17 June 2022
Our Ref: 21007D.6NB (S4.55(2))

**RE: SECTION 4.55(2) APPLICATION TO MODIFY
DEVELOPMENT CONSENT SSD-11920082
HASTINGS SECONDARY COLLEGE – PORT MACQUARIE CAMPUS
16 OWEN STREET, PORT MAQUARIE**

DFP has been commissioned by School Infrastructure NSW (SINSW) to prepare an application under section 4.55(2) of the *Environmental Planning and Assessment Act 1979* (EP&A Act) to modify development consent No. SSD 11920082 (as modified). The modifications include:

01 ELEVATION CAPA West Elevation  
1:100

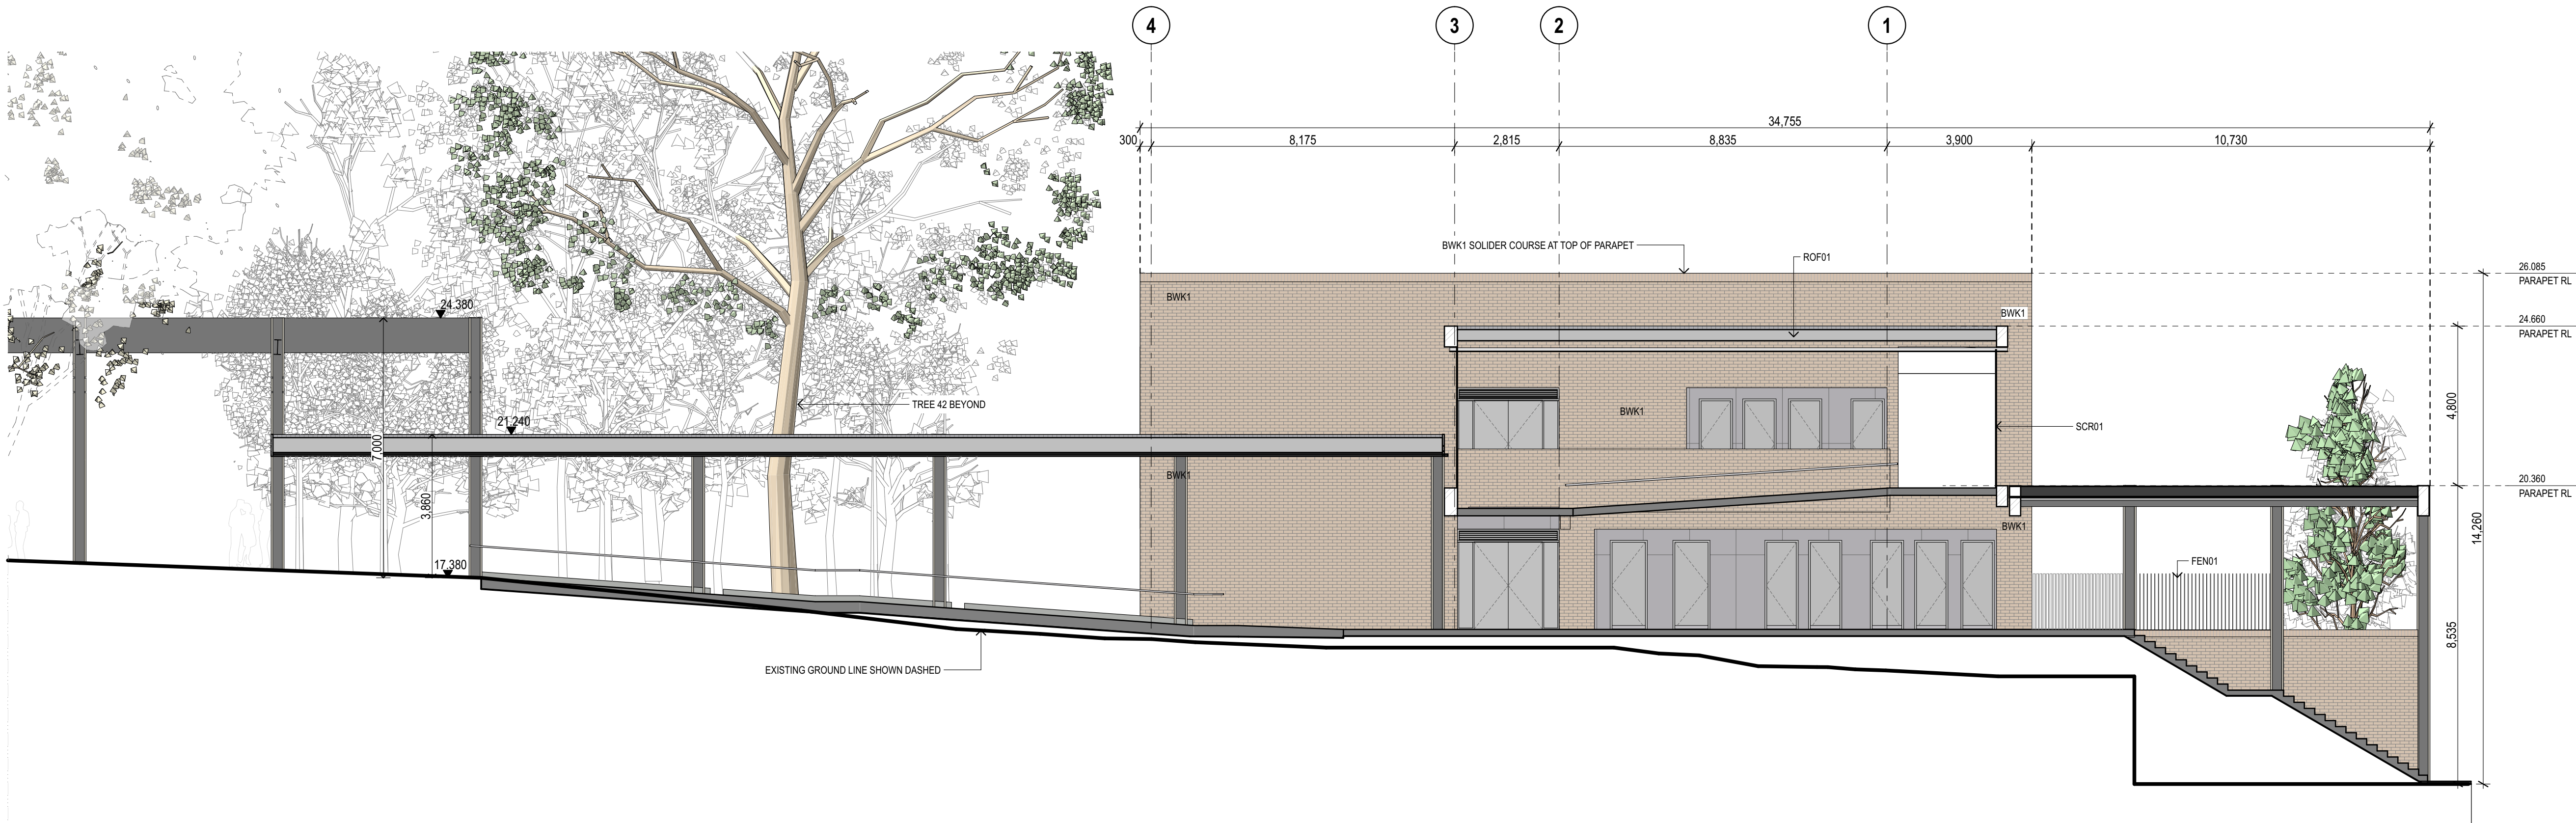
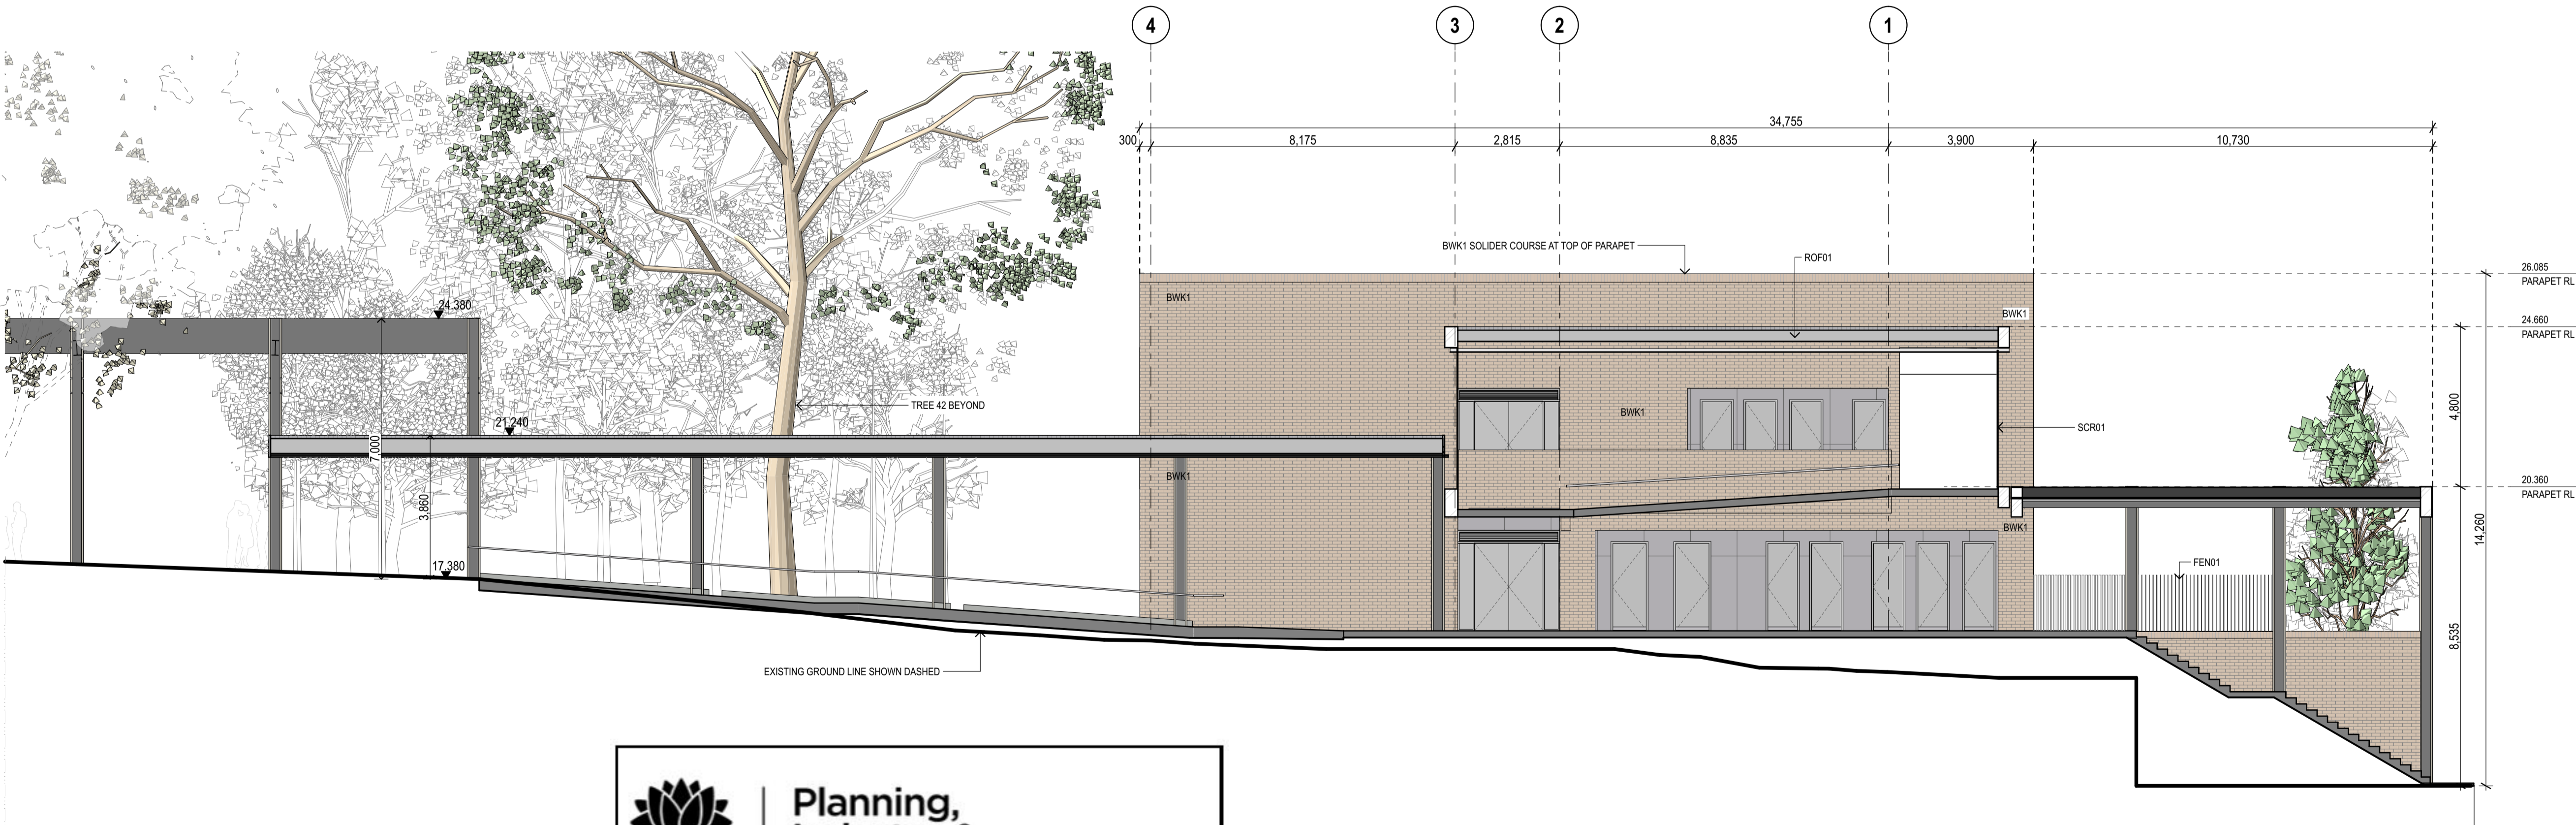
- Amendment of stair locations to avoid existing services;
- Removal of works to Building L;
- Installation of mechanical plant on canopy roof, east of CAPA building;
- Installation of external stairs to CAPA building;
- Reconfiguration of Building A entry, including reconfiguration of undercover walkway;
- Reconfiguration of landscaping at entrance;
- Addition of landscaping to north of Building B and north of PCYC;
- Alteration of scope of works to Building B;
- Change in materials;
- Change to window placement and louvers on CAPA building;
- Minor internal modifications

The proposed external alterations will alter the Owen Street streetscape through the addition of mechanical plant, external stairs and a reconfiguration of the entrance to Building A and the associated undercover canopy area. Overall, the modifications have minimal visual or height impact to the streetscape when compared to the approved design. The approved height of the development is 13.88m. The height of the CAPA with the mechanical plant is 11.96m. **Figures 2 and 3** are comparisons of the Owen Street elevation with **Figure 2** being the approved elevation and **Figure 3** incorporating the proposed modifications.
